Thank you for the opportunity to comment on the Paquette Short Plat, SP-08-57. Pursuant to the Memorandum of Agreement between Kittitas County and the Washington State Department of Ecology all residential well connections serving the proposed lots shall be required to have meters installed. Metering results shall be recorded in a manner consistent with Kittitas County and Washington State Department of Ecology requirements. The requirement to meter only applies if you rely upon the RCW 90.44.050 exemption from permitting through ecology.

TO: Allison Kimball, Community Development Services
FROM: Christina Wollman, Planner II *cw*
DATE: March 10, 2009
SUBJECT: Paquette Short Plat SP-08-00057

Thank you for the opportunity to comment on the short plat of approximately 11 acres into 2 lots, proposed by Daniel Paquette [SP-08-0004-57]. We have reviewed the application and have the following comments.

PAQUETTE SHORT PLAT  
 PART OF SECTION 26, T. 19 N., R. 17 E., W.M.  
 KITTITAS COUNTY, WASHINGTON

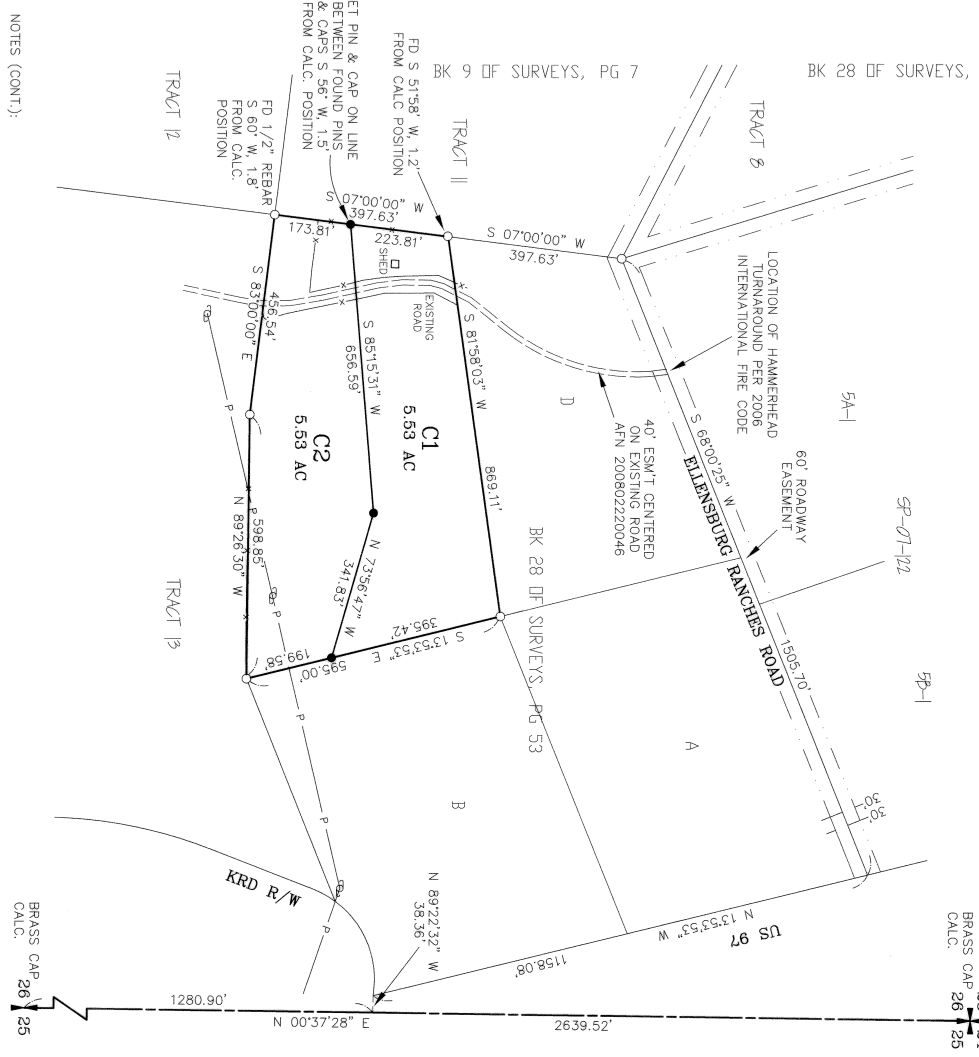
1. US 97: The plat incorrectly refers to US 97 as State Highway SR 131. The road shall be labeled as US 97 on the final plat.
2. Access via US 97: Ellensburg Ranches Road, the access for the proposed lots, originates from an existing approach off US 97. The Washington State Department of Transportation has jurisdiction over US 97. A minor connection permit is on file with WSDOT.

6. Turnaround: Ellensburg Ranches Road requires a turnaround. A hammerhead turnaround may be constructed in lieu of a cul-de-sac. Additional easement may be required. Turnaround locations shall be shown on the plat. Hammerheads must be constructed as specified in the 2006 International Fire Code. Cul-de-sac requirements are shown below.
